ADDENDUM – Landscape and Visual Impact Appraisal – Dearne Reach 1 Wetlands

TO	Kirkless Council	FROM	WSP
DATE	01 March 2024	CONFIDENTIALITY	Public
SUBJECT	Addendum to the Landscape and Visual Impact Appraisal, for Dearne Reach 1 Wetlands, Planning Application reference 2023/62/93805/E planning portal reference PP-12603433 following changes to the site layout.

Drawing Number:
YW.202043.02 MMB WWT WWT DR C 1012

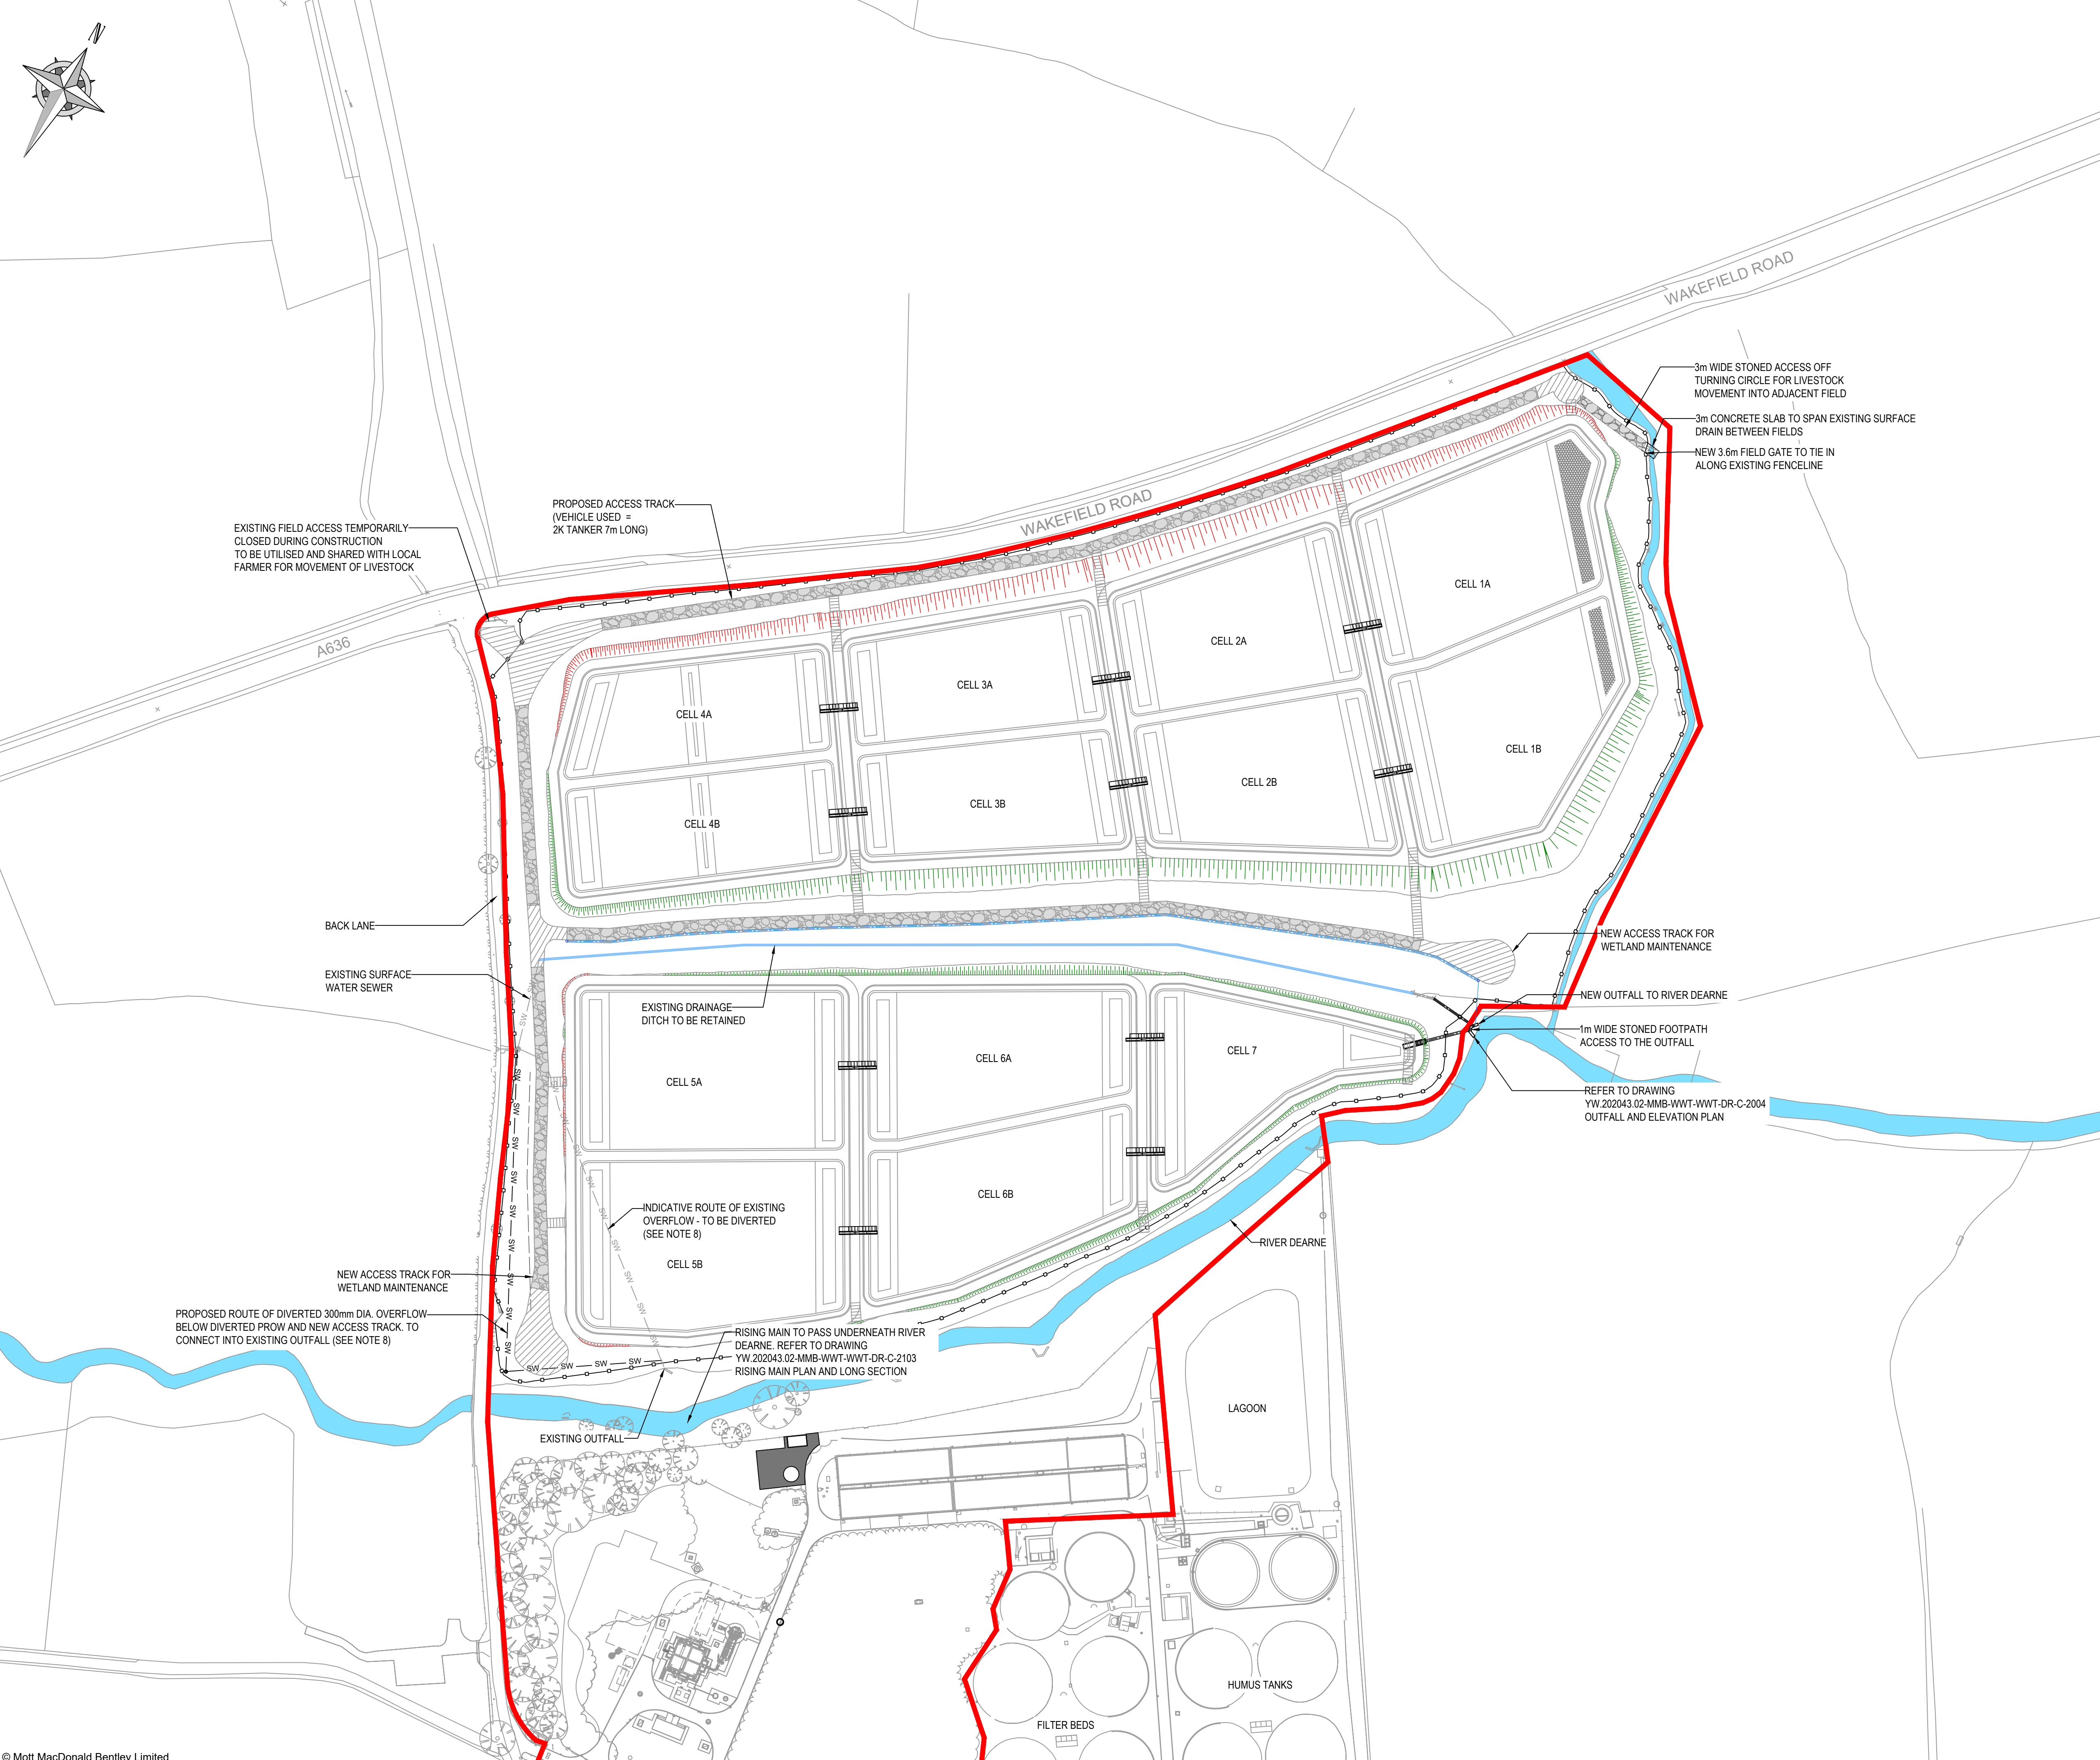
- The revised Proposed Development currently under assessment is illustrated upon supporting Figure ICW Site Layout - YW.202043.02-MMB-WWT-WWT-DR-C-1012

The configuration of the cells has been revised in order to allow for the retention of the existing hedgerow, that cross the site from west to east demarcating the land parcels that make up the site, and retaining the existing scale and pattern of the landscape. In addition to the above, the retention of the existing hedgerow will help reduce the impacts of the proposed development upon users of PRow (footpath) KL/DEN/13/20, along the section of the route diverted by the Proposed Development.

In general, the revised change to the layout of the site, will have a beneficial effect upon the magnitude of change, proposed by the Proposed Development upon the receiving environment. The retention of the hedgerow now separating the cells to the north from those to the south, will reduce the magnitude of change, when viewed from viewpoints 1 and 5, principally associated with effects upon users of PRoW (footpath) KL/DEN/13/20. From here, the nature of the effect is unlikely to change significantly between operational year 1 and operational year 15, due to limited land availability allowing for the provision of screen planting directly to the north of the diverted PRoW.
